Appeal Decision

Appeal Ref: APP/R5510/W/22/3296539

51A The Drive, Ickenham, UB10 8AG

- The appeal is made under section 78 of the Town and Country Planning Act 1990 against a refusal to grant planning permission.
 - The appeal is made by Mr D Singh against the decision of London Borough of Hillingdon.
 - The application Ref 66020/APP/2021/4369, dated 29 November 2021, was refused by notice dated 25 February 2022.
 - The development proposed is Erection of leisure building following demolition of existing structure.
-

00 - Proposed Plan
1 : 100

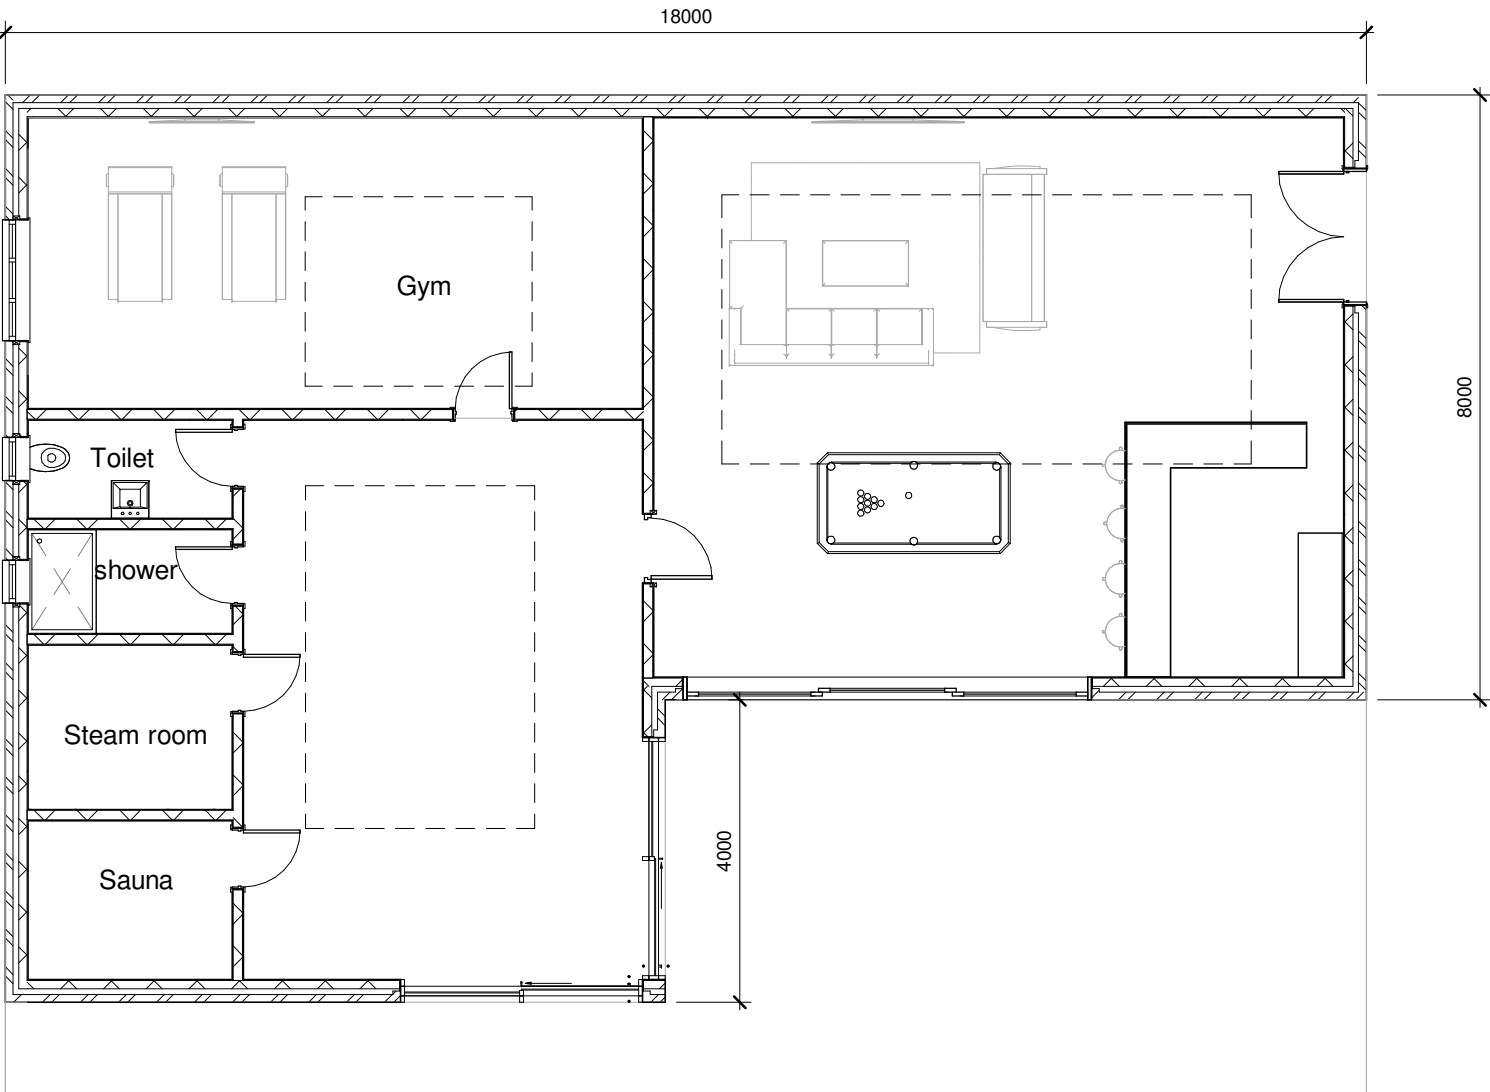
7. The proposed outbuilding is shown on the, very limited, submitted plans as being notably larger than the existing outbuilding and of some scale in itself, described in the Officers report as having a footprint of some 180 square metres.

9. That the materials of the outbuilding would be matching, and a flat roof used would improve the appearance and reduce the prominence of the proposed outbuilding. Nonetheless the proposed outbuilding would erode the open character of the area.

11. Therefore, while the need for the larger building is not unreasonable, nonetheless the proposed development would result in a noticeably more developed plot than the prevailing character and appearance of the area.
